DRB Application No.: 05DRB-01146 (P&F) Project # 1004325  
 Project Name: HOLIDAY PARK UNIT 11 Project # ~~1004257~~  
 Agent: Surveys Southwest Ltd Phone No.: 998-0303

**CITY OF ALBUQUERQUE  
PLANNING DEPARTMENT  
July 20, 2005  
DRB Comments**

**RE: Holiday Park, Unit 11/minor p&f plat**

PLAT OF
 TRACTS F-1 & F-2
 HOLIDAY PARK UNIT 11
 SECTION 3, T. 10 N., R. 4 E., N.M.P.M.
 CITY OF ALBUQUERQUE
 BERNALILLO COUNTY, NEW MEXICO
 JUNE 2005
 SHEET 2 OF 2

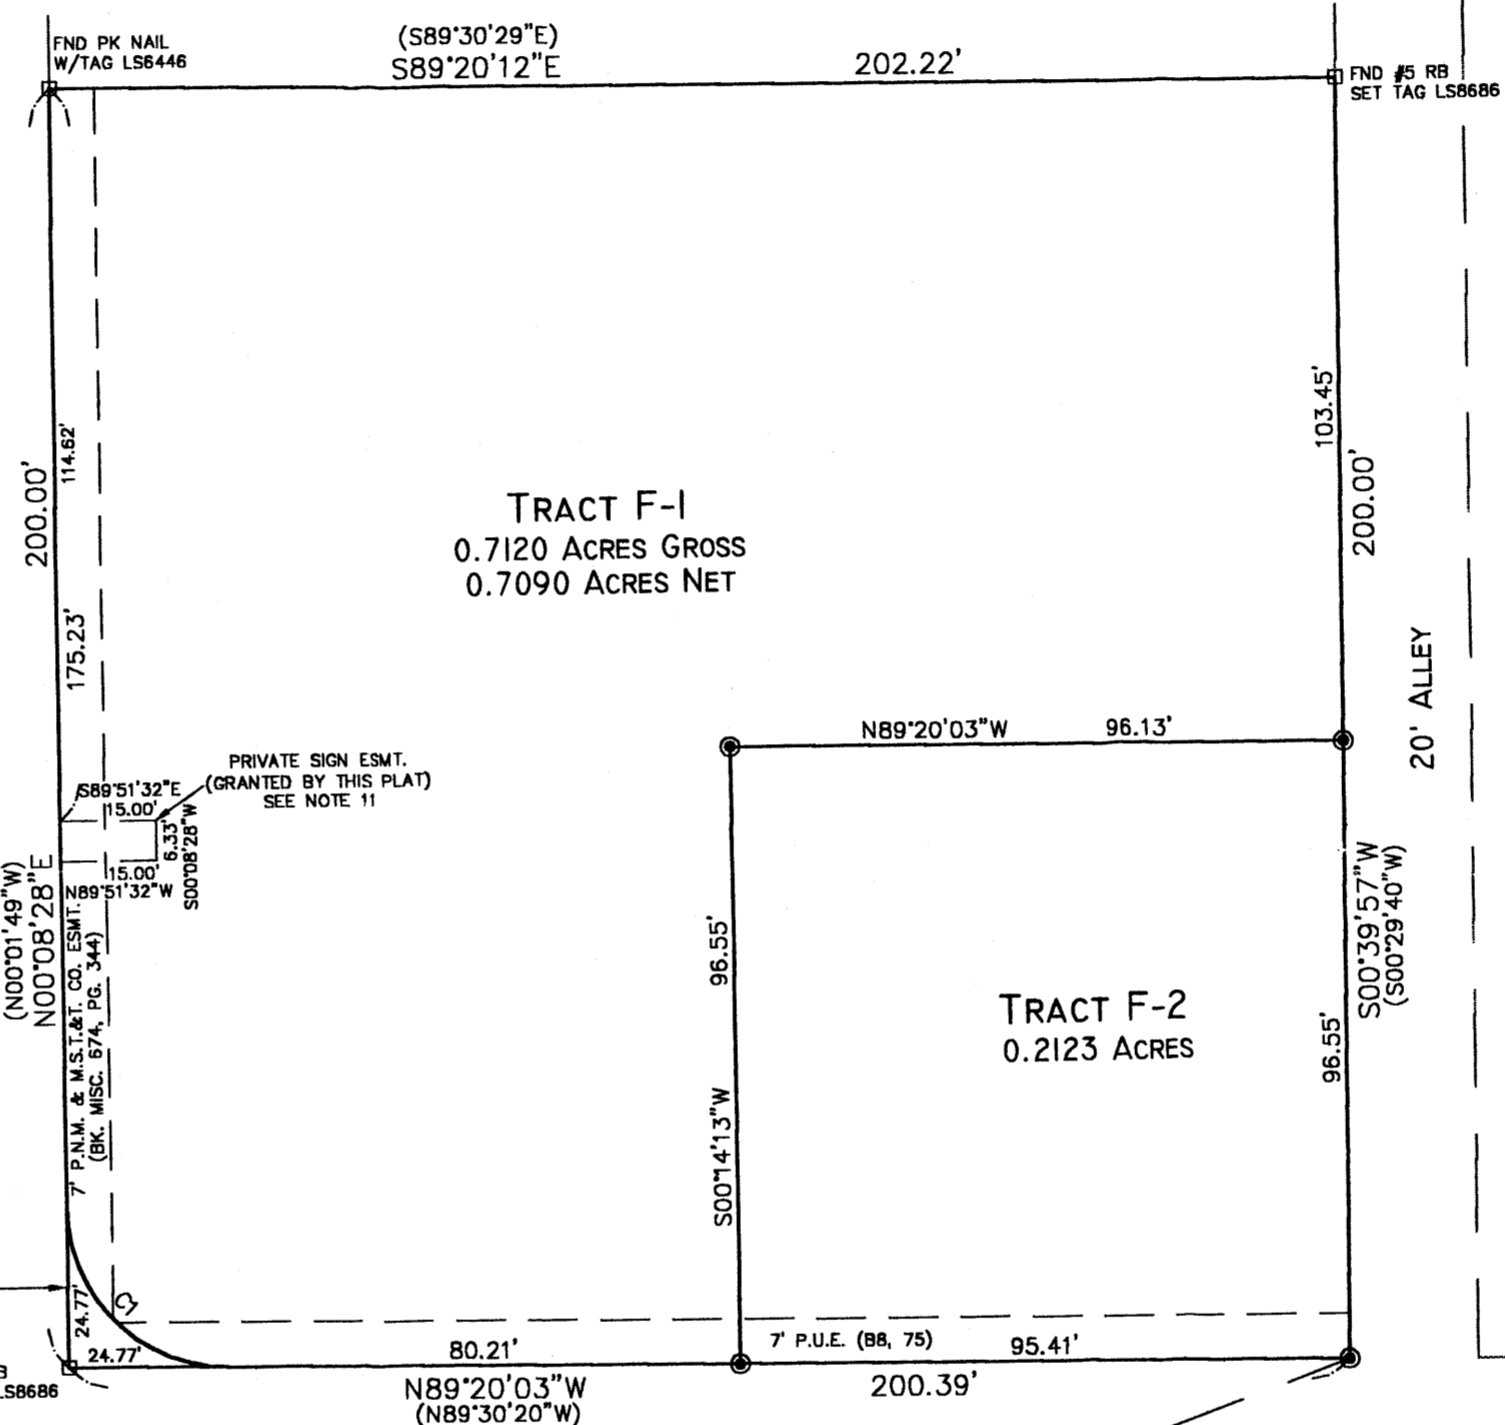
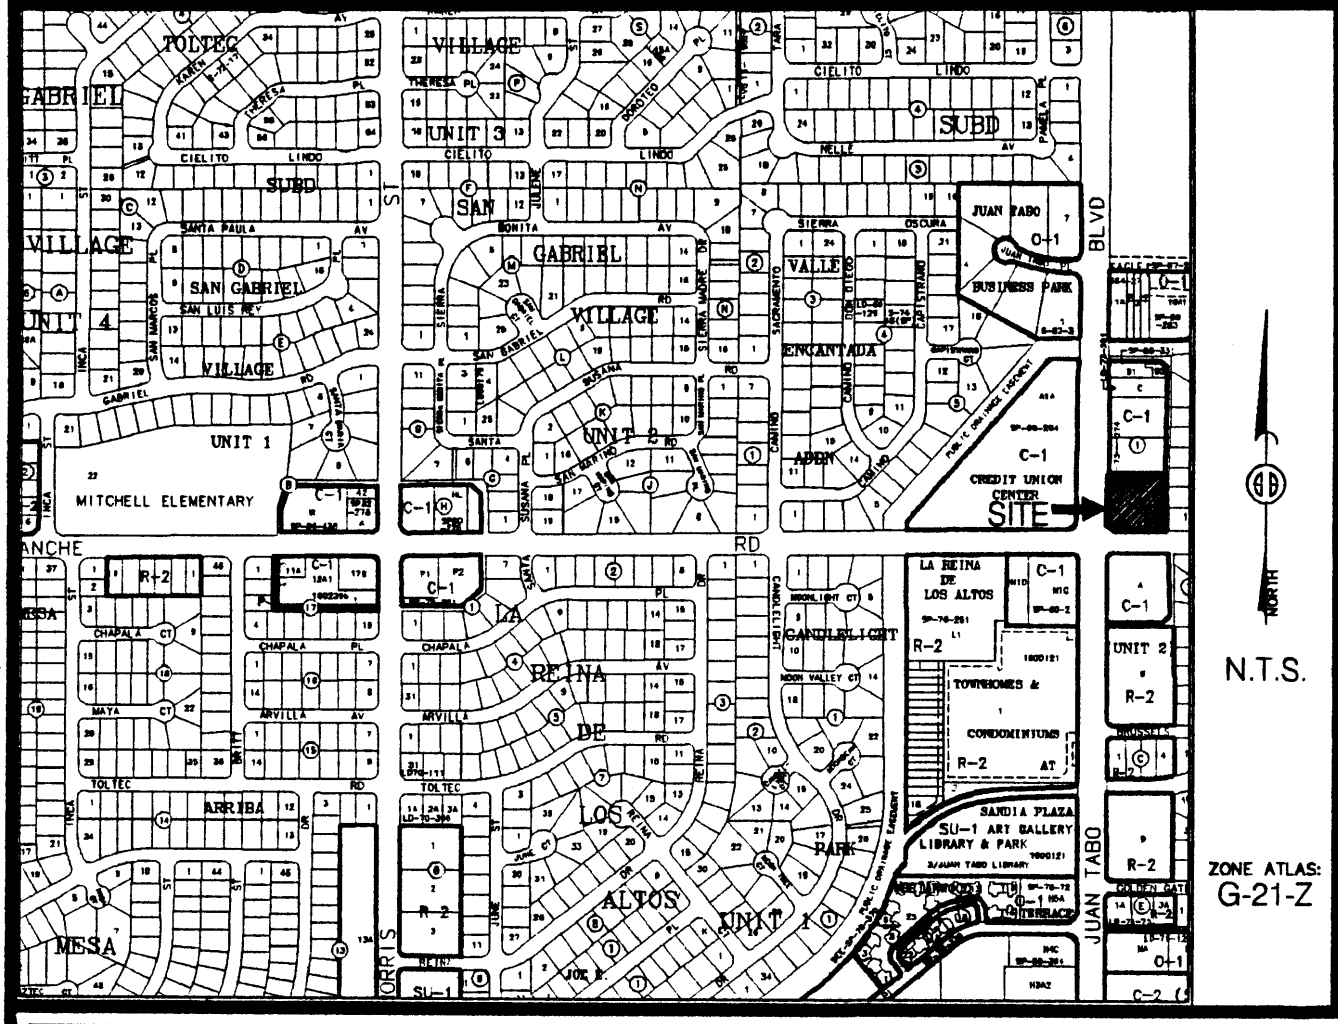
There is no minimum lot size requirement for the C-1 zone. However, reciprocal parking easements between two or more lots are not allowed. Each lot should have its own parking requirements contained on that lot.
